**Phone:** 0300 123 6780  
**Email:** SUDS@lancashire.gov.uk  
**Date:** 14 October 2020

### APPLICATION CONSULTATION RESPONSE

<b>Application Number:</b>	3/2020/0332
<b>Location:</b>	Land off Sheepfold Crescent Barrow BB7 9XR
<b>Proposal:</b>	Application for reserved matters for appearance, landscaping, layout and scale following outline planning permission 3/2018/0910 for 20 bungalows for the elderly (of which two are affordable) and 6 affordable apartments.

Client	LEA HOUGH & COMPANY LTD.
Job title	BARROW BROOK WHALLEY
Drawing title	DRAINAGE STRATEGY PLAN
Date	1/5/20
Scale	6:120
Drawing No	20046/01/1
Rev	A

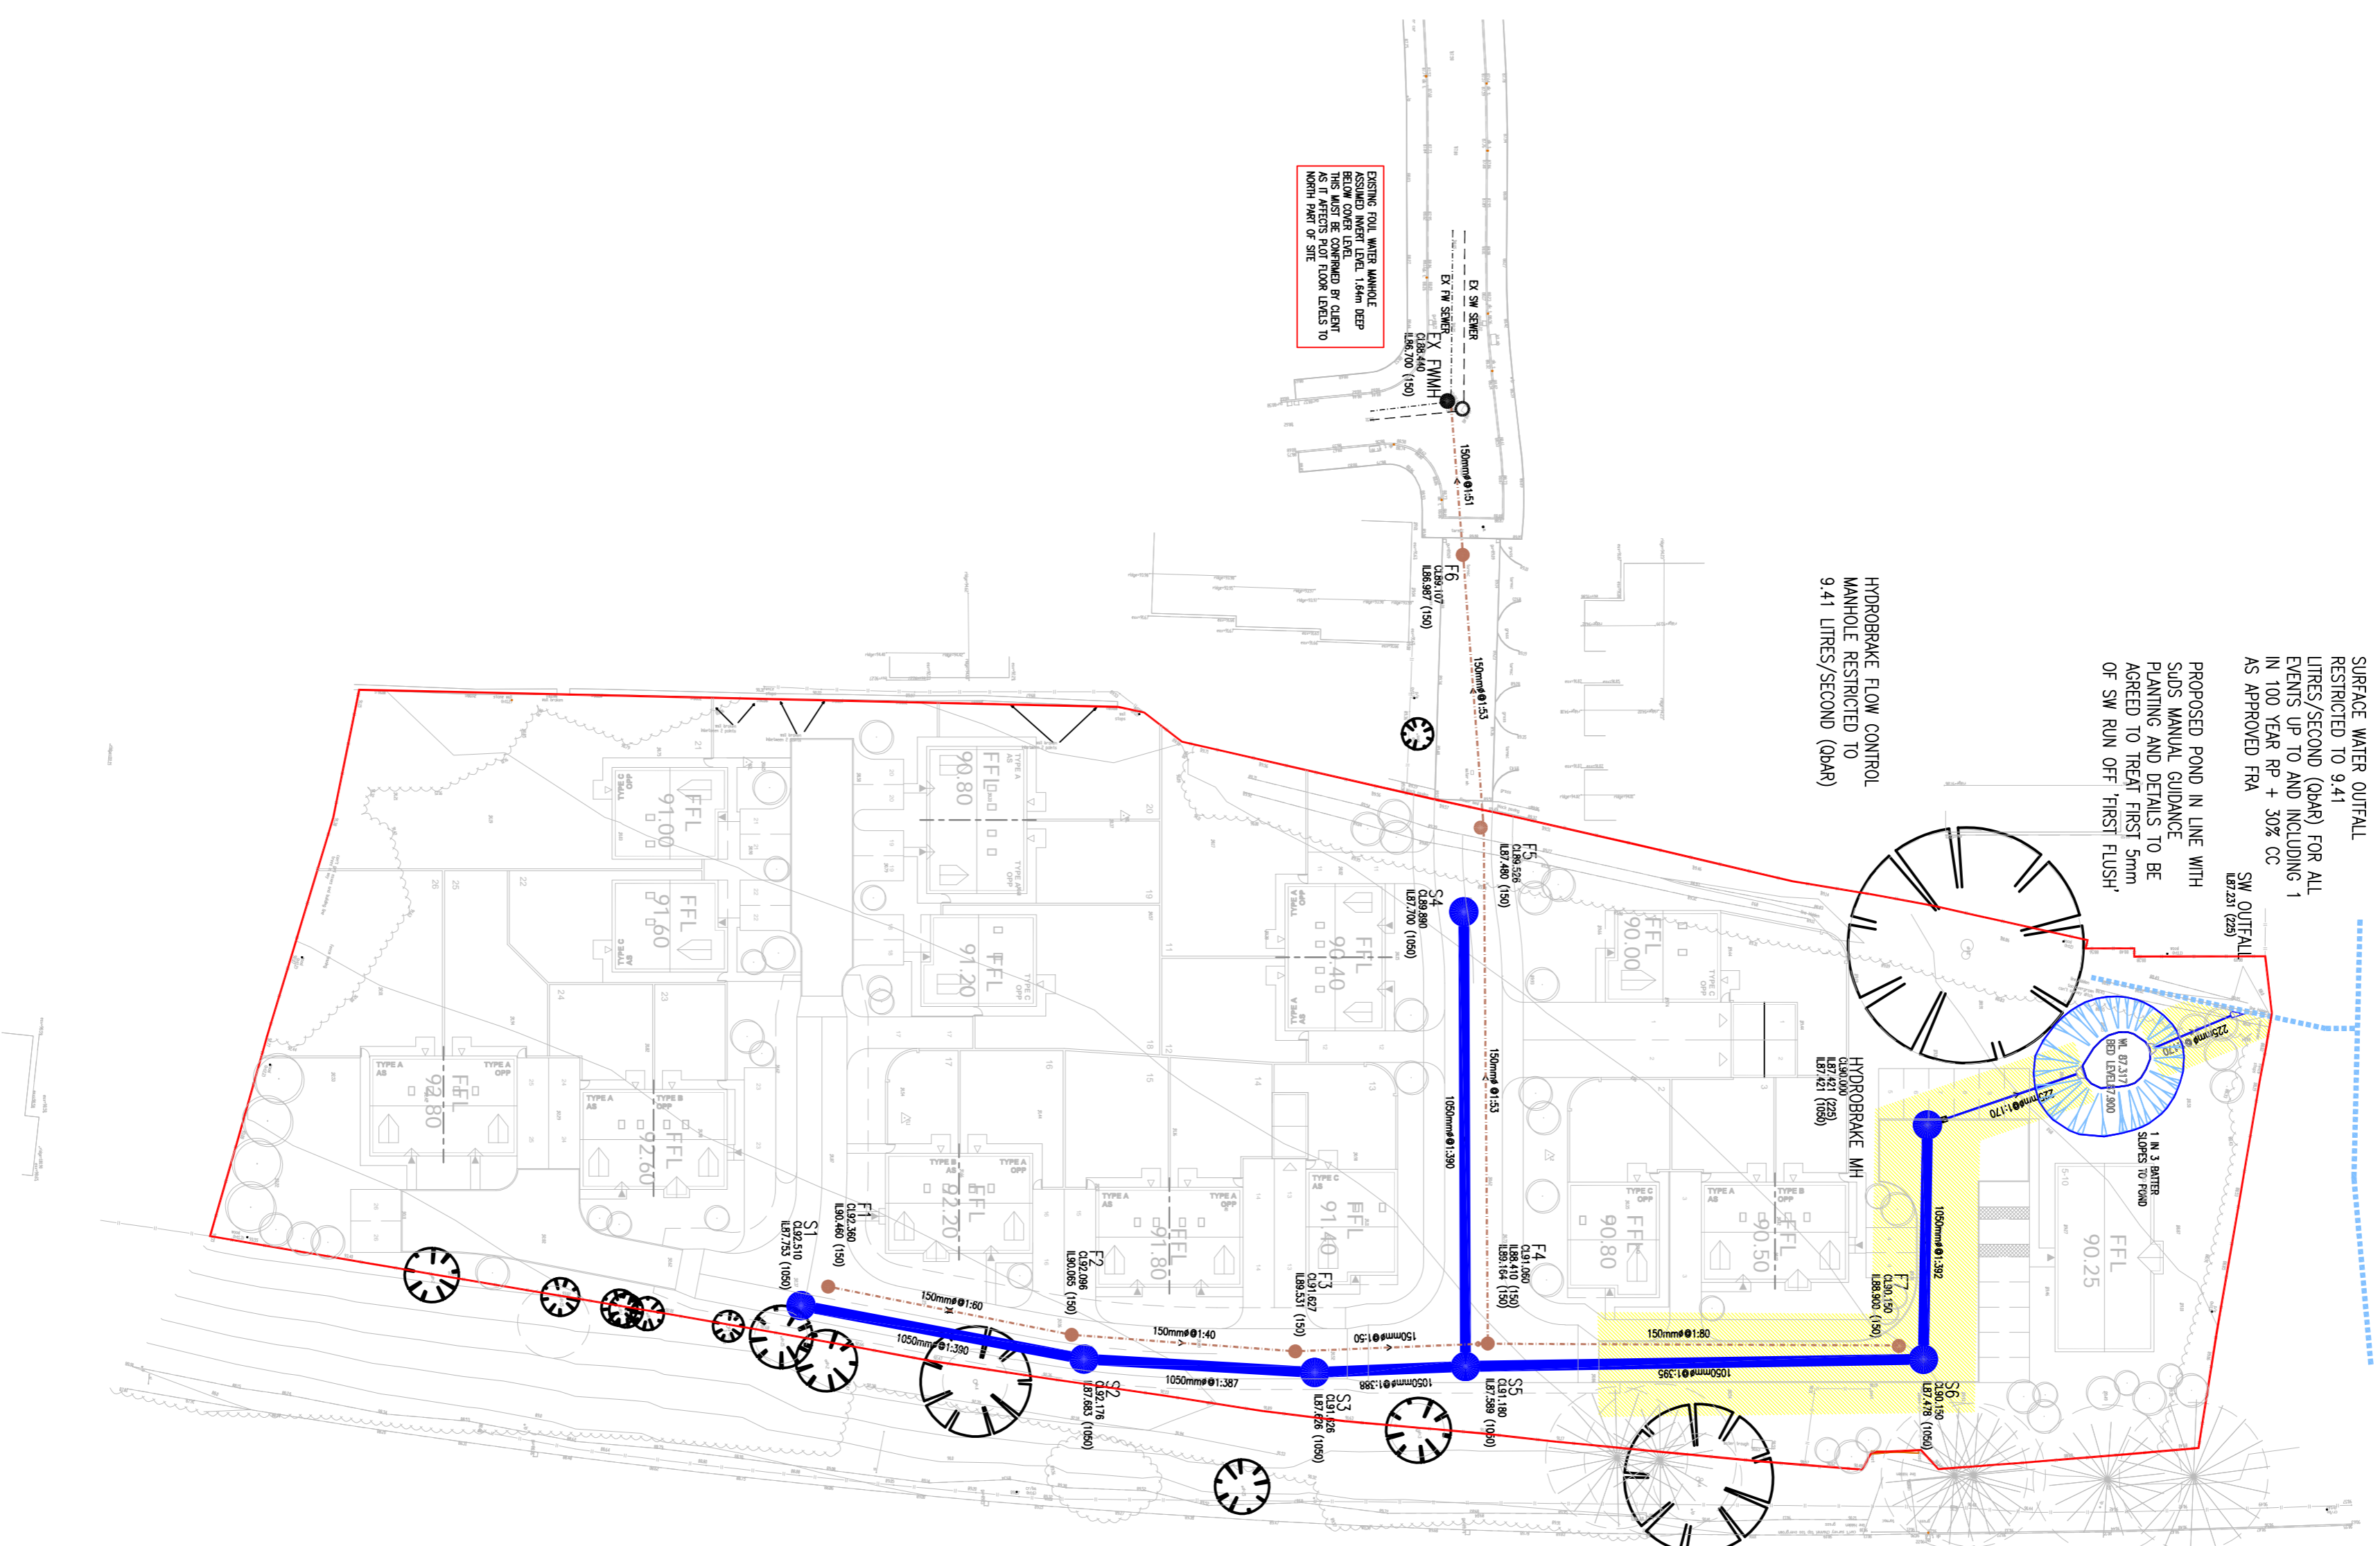
The surface water drainage scheme set out on drawing 20046/01/1 Rev C is only a preliminary issue and is still subject to change following further detailed design and investigation. To comply with the requirements of condition 7, the applicant will need to provide the final details of the surface water drainage scheme once all detailed design and investigation work has been completed. The final strategy will need to be submitted to and approved by the LPA prior to the commencement of any development, and must comply with the requirements of the National Planning Policy Framework and the non-statutory technical standards for sustainable drainage systems; March 2015. The strategy must also be accompanied by an appropriate management and maintenance plan that details how the surface water drainage network will be managed and maintained over the lifetime of the development. The LLFA is satisfied that these details can be secured through a separate application to discharge the requirements of condition 7.

drainage system should be designed to make sure there is no increase in the rate of runoff discharged from the site for the upper end allowance – i.e. 40% based on the expected lifetime of the development. The current proposals only provide an additional 30% allowance for climate change which is insufficient and contrary to advice. An additional 10% allowance should also be added to drainage system to account for future urban creep, i.e. the future conversion of permeable surfaces to impermeable surfaces over time, e.g. surfacing of front gardens to provide additional parking spaces, extensions to existing buildings and creation of large patio areas etc. I cannot see any additional allowance for urban creep within the current proposals, so this will need to be factored in at detailed design stage. Otherwise it is unclear how the future impacts of urban creep will be avoided over the lifetime of the development.
